Application for a Non-Material Amendment Following a Grant of Planning Permission

22/03210/HHD

I would like to update the approved Floor Plans from 01-100C to 01-100D

PROPOSED GROUND FLOOR PLAN
1:100

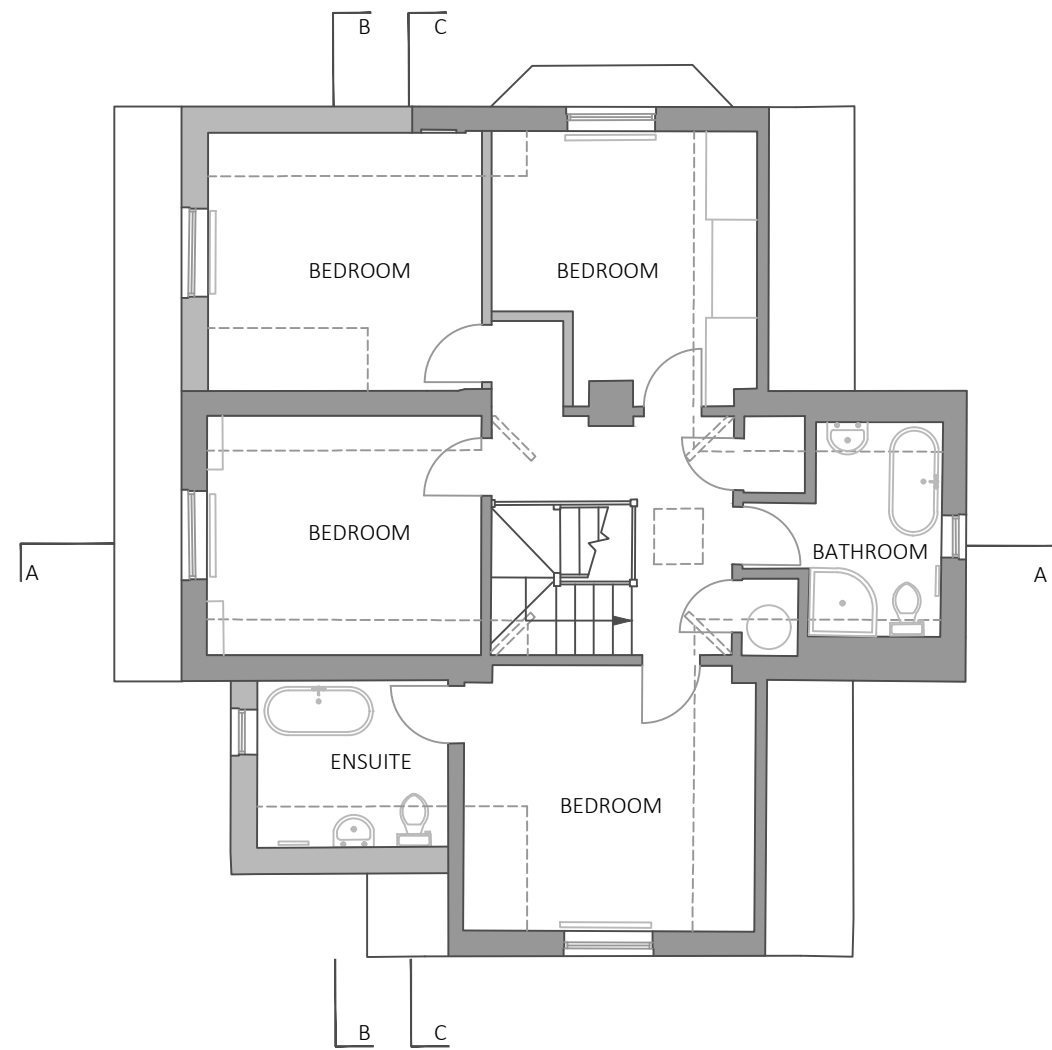
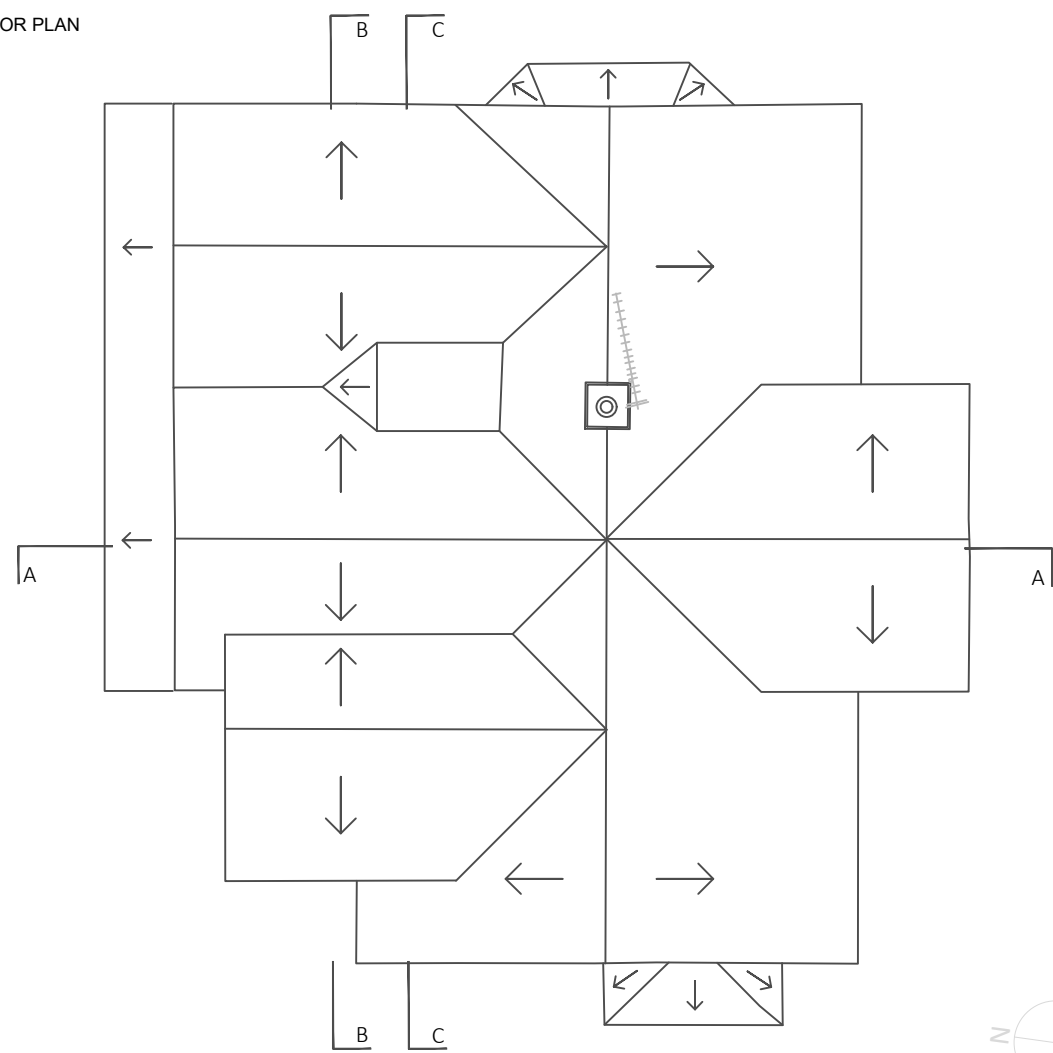
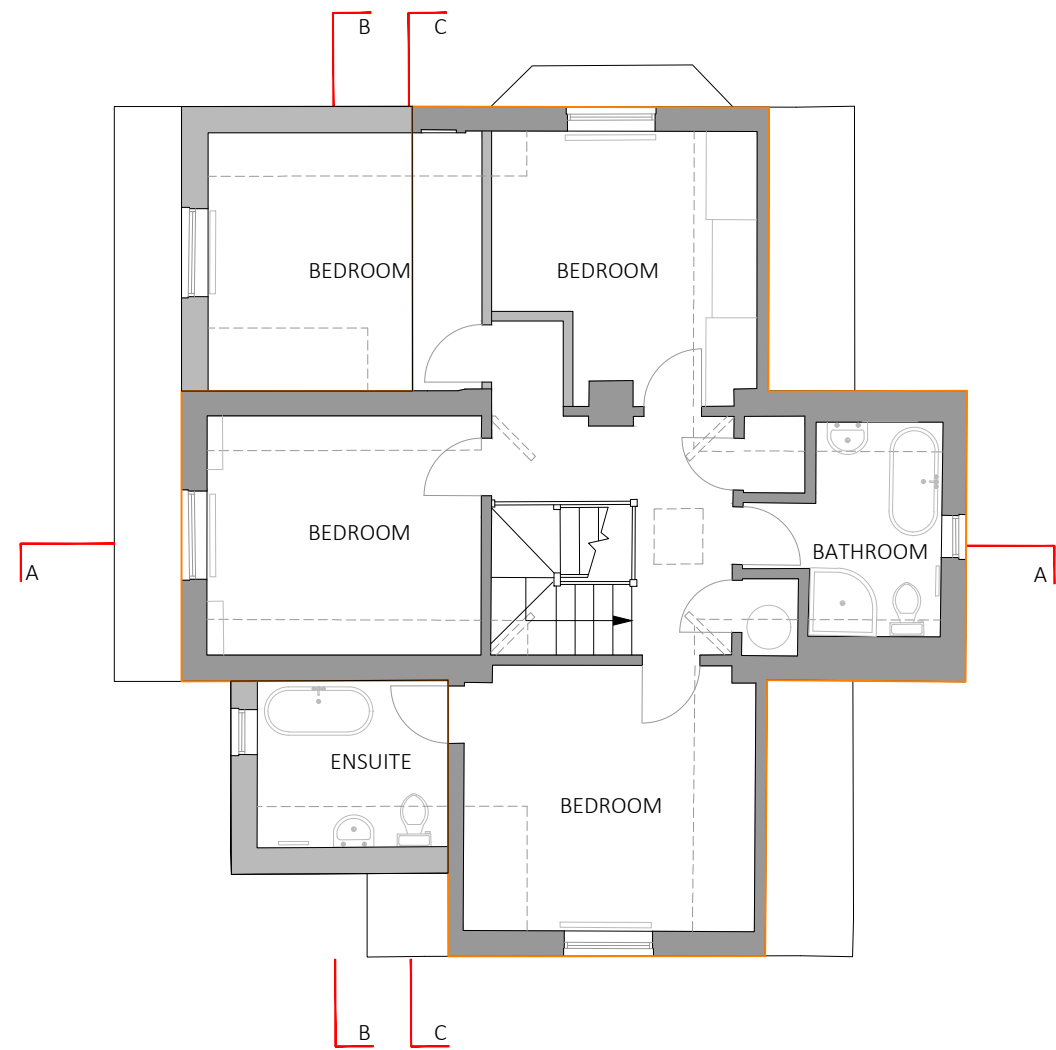
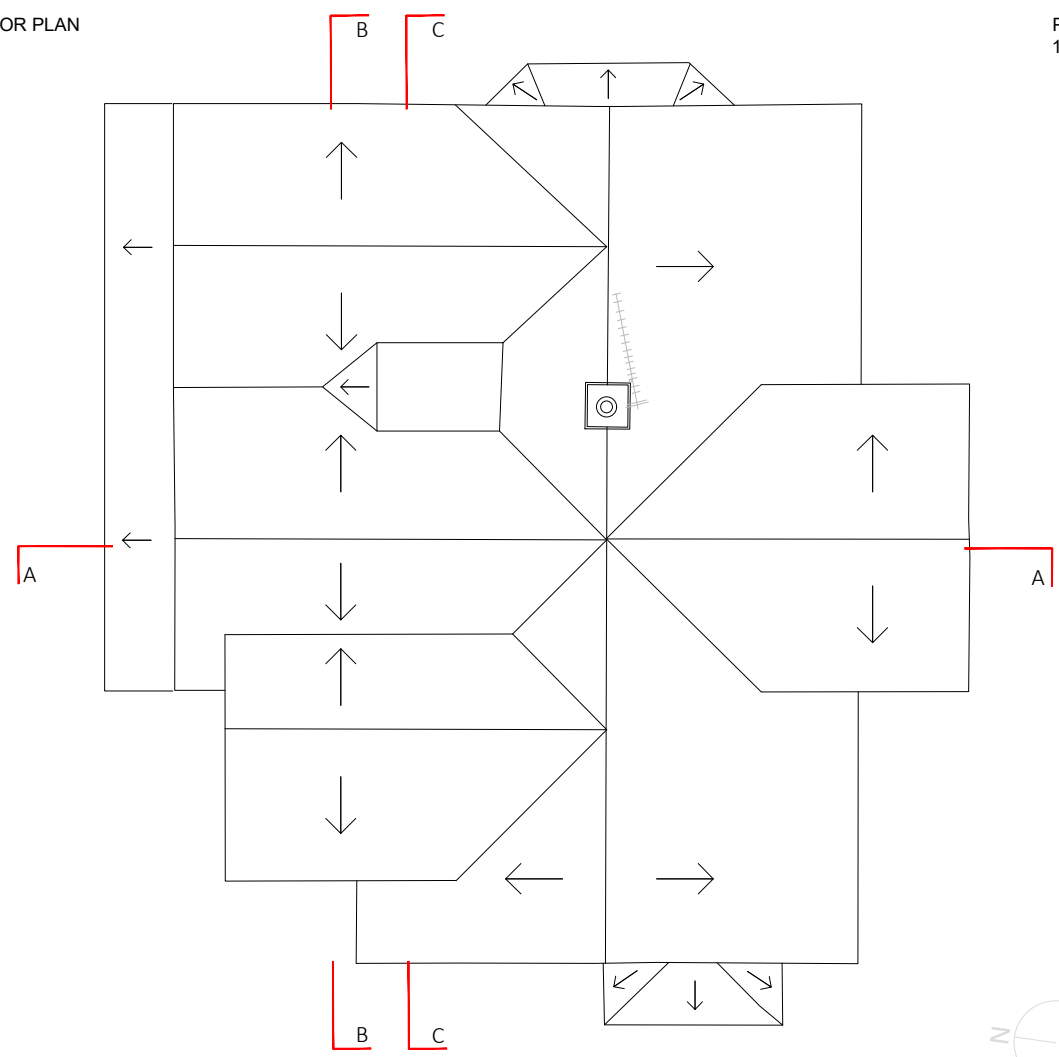
A door has been illustrated along the East Elevation in Plan next to the bay window but this is actually a window, as illustrated on the proposed elevations.

A door was originally illustrated in the floor plans and a window in elevation. This was a mistake and for continuity we would like to update the floorplan to illustrate the window that is actually in-situ.
